From: Pam Swendrowski
To: [Robin Proebsting](mailto:Robin.Proebsting)
Subject: Fw: File SUB19-002 (SEP19-005)
Date: Thursday, May 9, 2019 9:49:17 AM

From: Pam Swendrowski <pkreif@yahoo.com>
To: robinproebsting@mercergov.org <robinproebsting@mercergov.org>
Sent: Thursday, May 9, 2019, 9:42:15 AM PDT
Subject: File SUB19-002 (SEP19-005)

3/1/19
 JOB NUMBER:
13-118
 SHEET NAME:
SP-01
 SHT **3** OF **9**

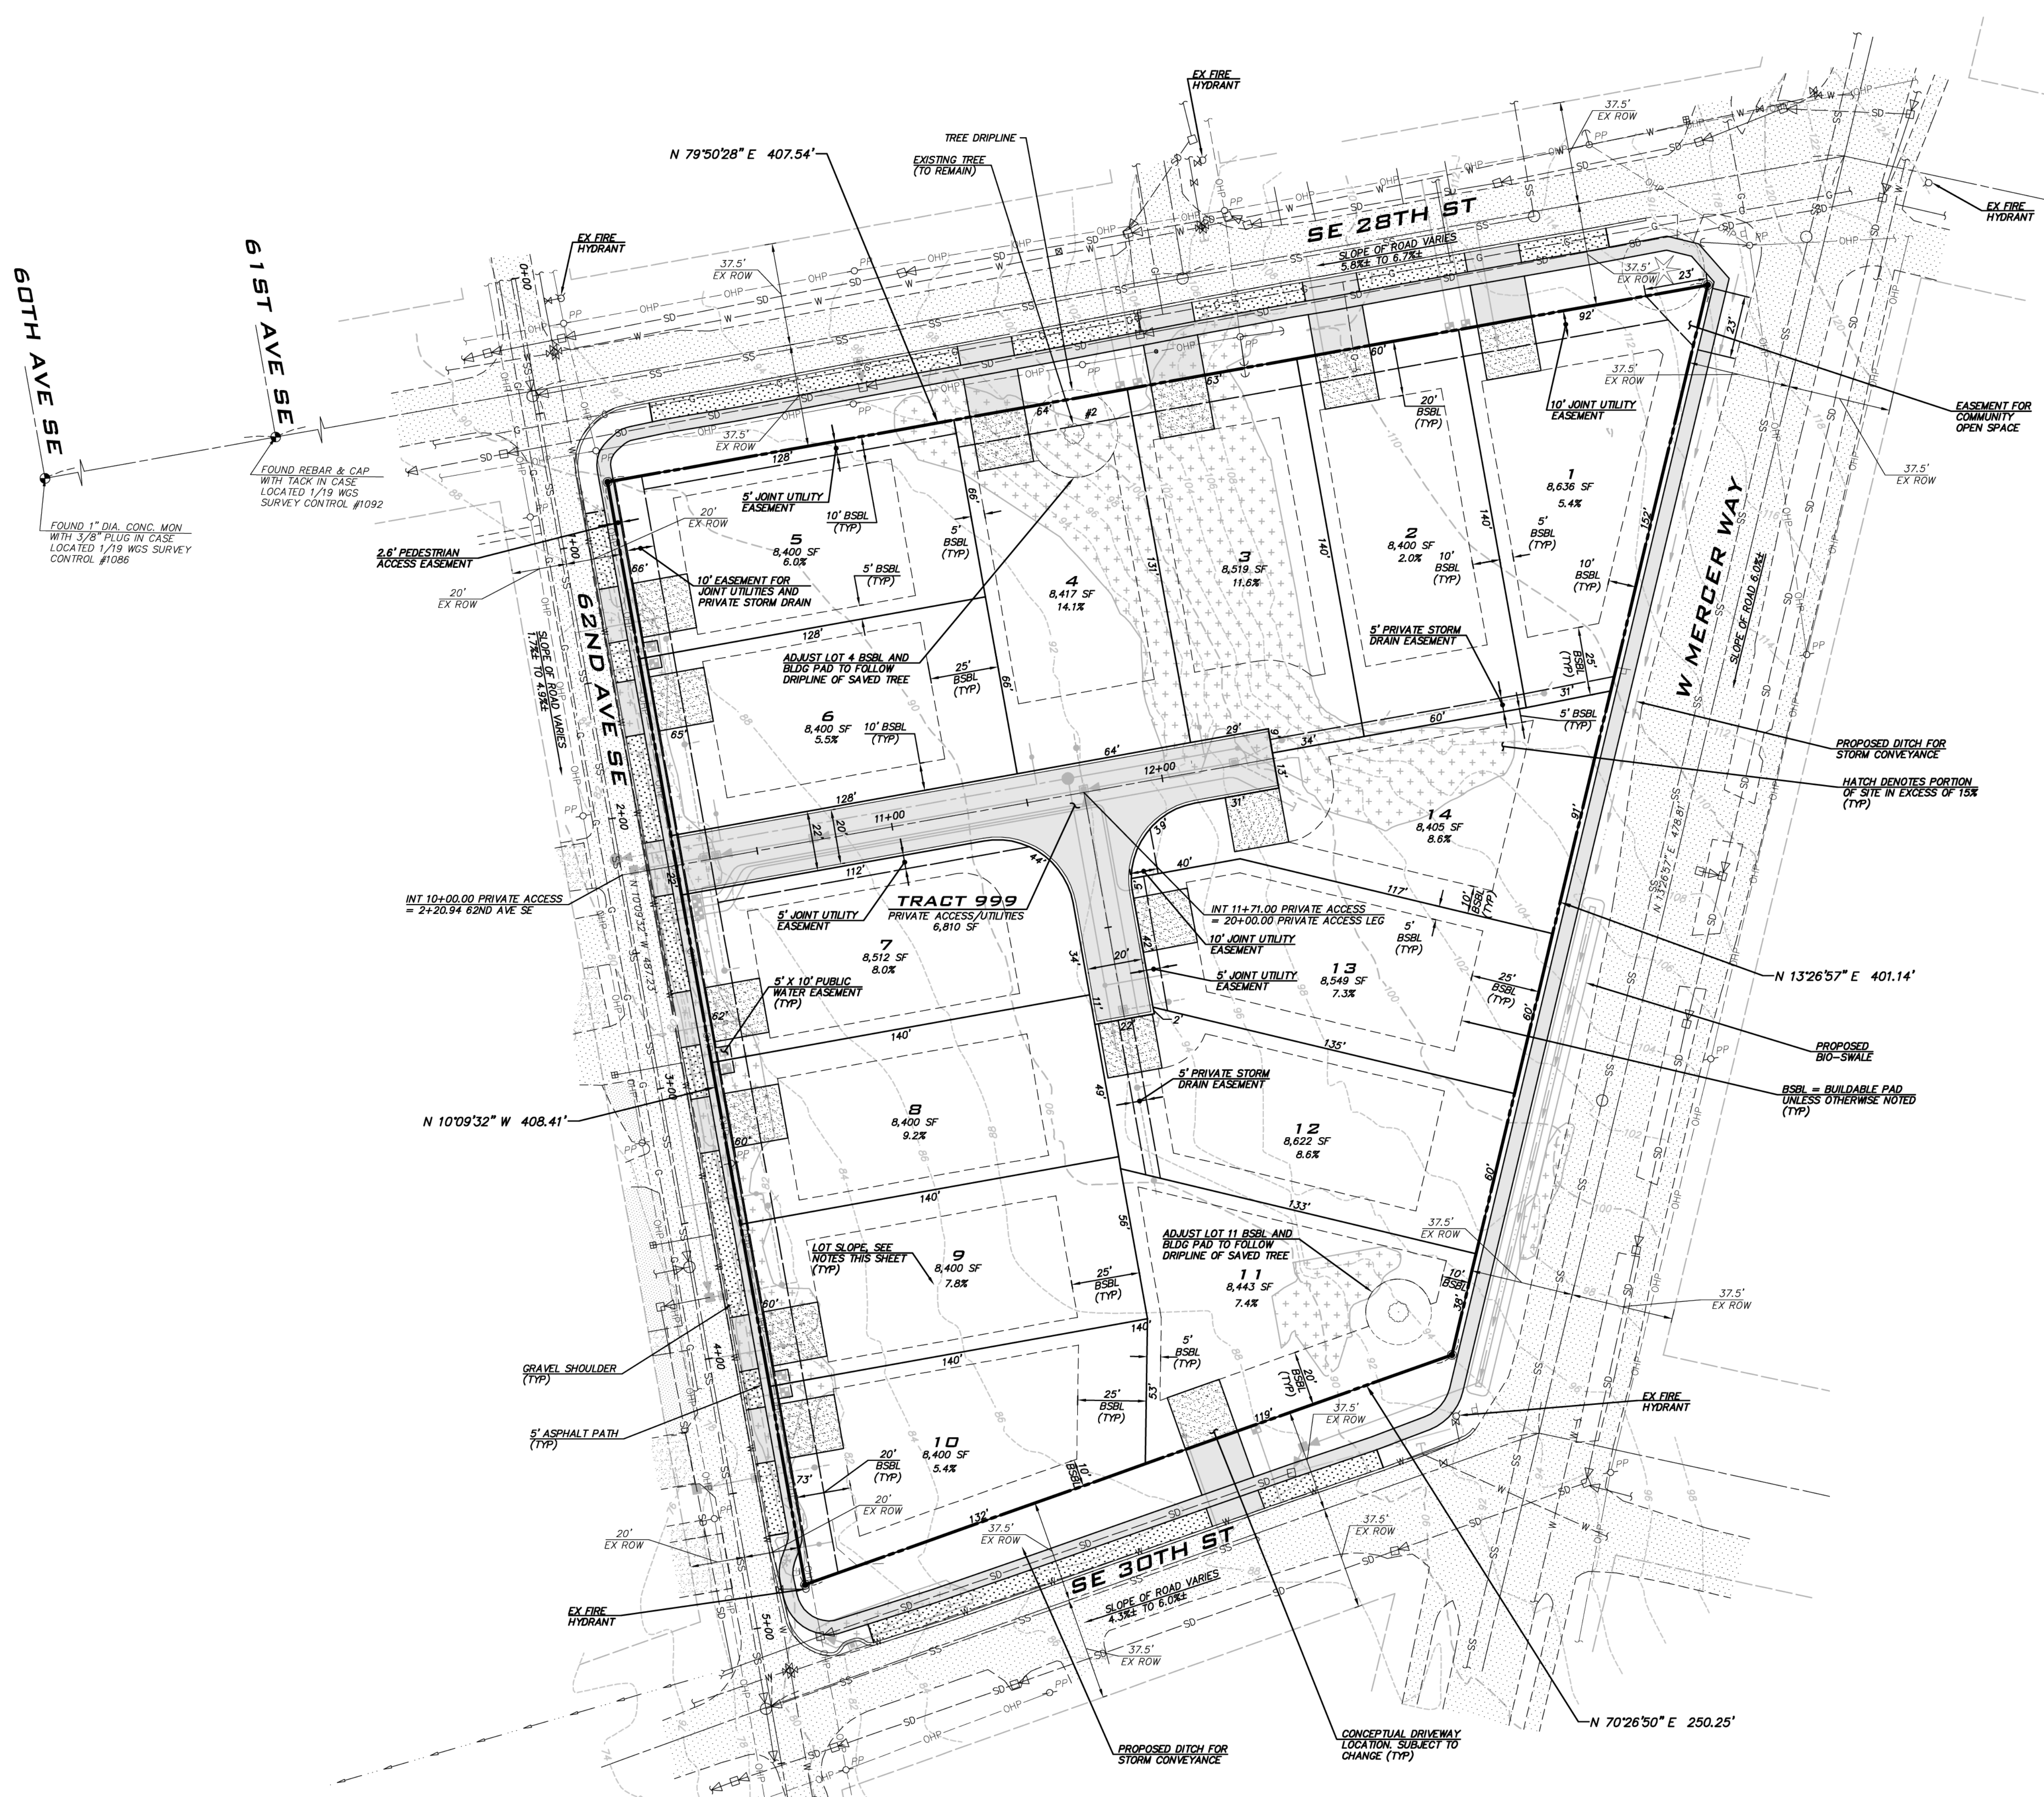
This email's purpose is to reject the access point for the 14 homes to be built on the 2.88 acre parcel. SE 62nd Ave is not a street that can handle 28 cars or more, nor is the neighborhood designed for cul de sacs. The East Seattle neighborhood's attraction is the grid pattern of the streets and the private streets that are more narrow than others.

I strongly recommend having 63rd continue through the 2.88 parcel of land or have access only from West Mercer Way to eliminate heavy traffic through the surrounding streets of the property.

I do not think 62nd ave se is a good cut through street looking at how it dead ends south and takes a small turn north, both directions north and south are narrow streets and cannot handle increased car traffic.

Please consider the quaintness of the neighborhood and keep the car traffic and access point on a road that can handle it, West Mercer Way.
